PORTLAND MAINE

October 1, 2007

Re: 38 Codman St., CBL: 129-H-012001
Building Permit # 07-0755 – Change of Use - To add a daycare center in the basement
Legal Use: Residential Two Family
Zone: R3

Basement Proposed

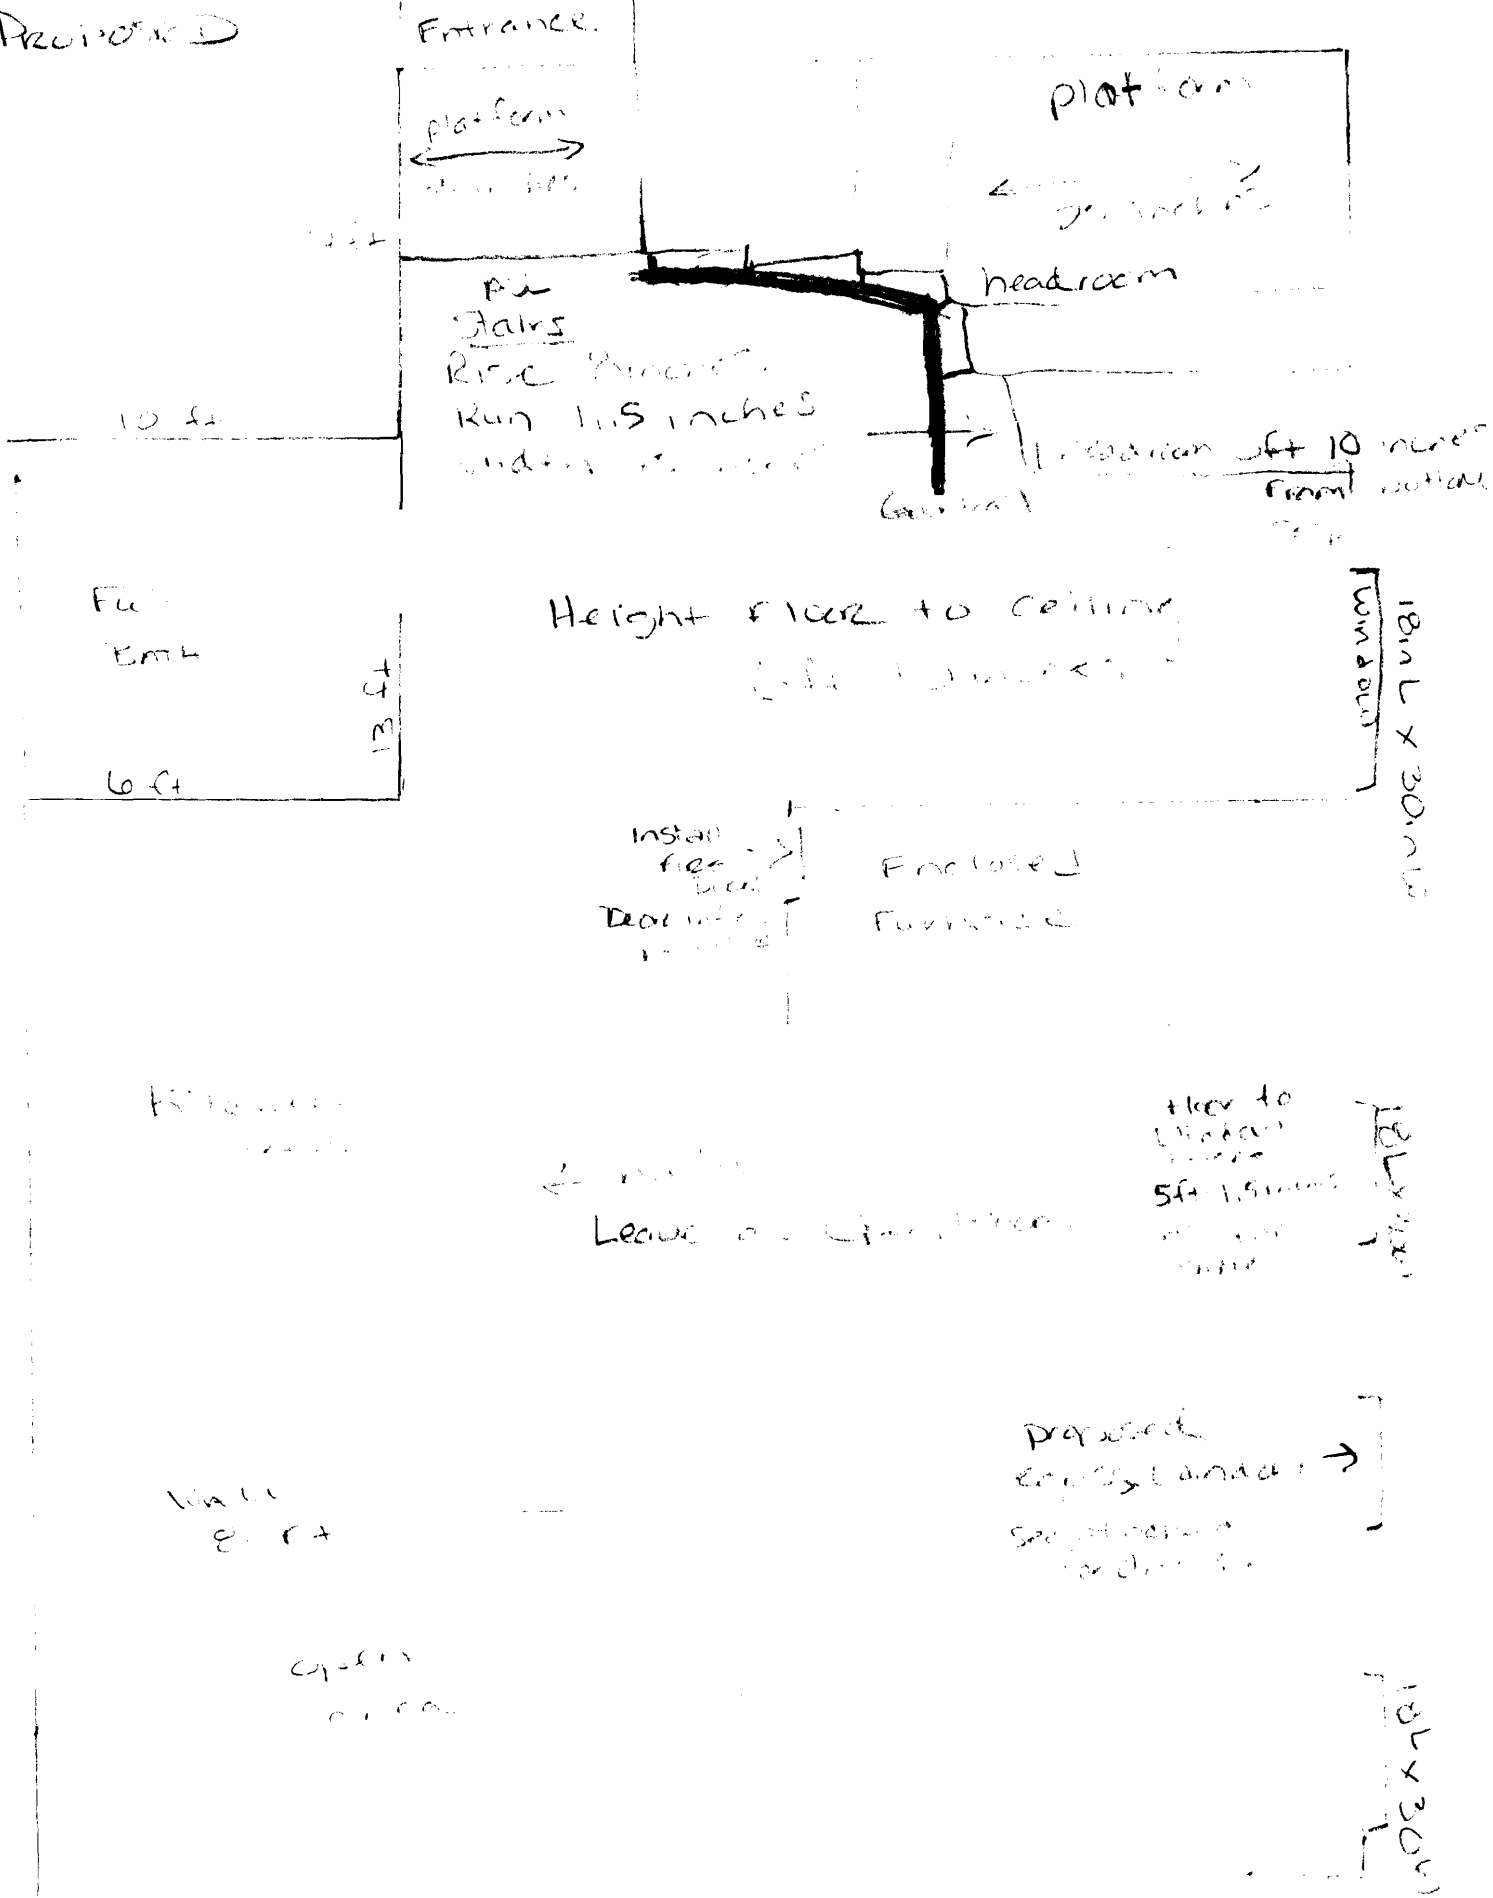
- You must have a 2-hour fire separation between the two dwelling units in the building in accordance with section 302.3.2. It can be reduced to 1 hour where the building is equipped with an automatic sprinkler system.
- You must have an automatic sprinkler system throughout every portion of the building below the level of exit discharge in accordance with section 903.2.2(1). The exception to this is where every classroom has at least one exterior exit door at ground level. Whereas you propose to house your day care in the basement, you would be required to install an automatic sprinkler system in the basement in order to comply with the IBC.
- You cannot have winders in a means of egress according to section 1009.8.

- The headroom in the stairwells must be 80” throughout: in accordance with section 1009.2.
- The ceiling height must be 7’ -6”in accordance with section 1208.2.

In order to proceed with your proposed use as planned you must be able to comply, at a minimum, with the above-listed requirements.¹ If you are unable to do so, you may proceed with a modified plan that would bring you into a less stringent category.

If you were to limit the day care to five or fewer children, you would fall under the residential “R-3” group in the IBC and would not have to comply with the above-listed requirements. You could also avoid the above requirements by converting your house to a single-family house and limiting the day care to five or fewer children, as child care facilities with five or fewer children that are within a single-family home are permitted to comply with the *International Residential Code* (IRC). Both the R-3 Group and the IRC have requirements that must be met, but they are less stringent than the Educational and Institutional Groups in the IBC.
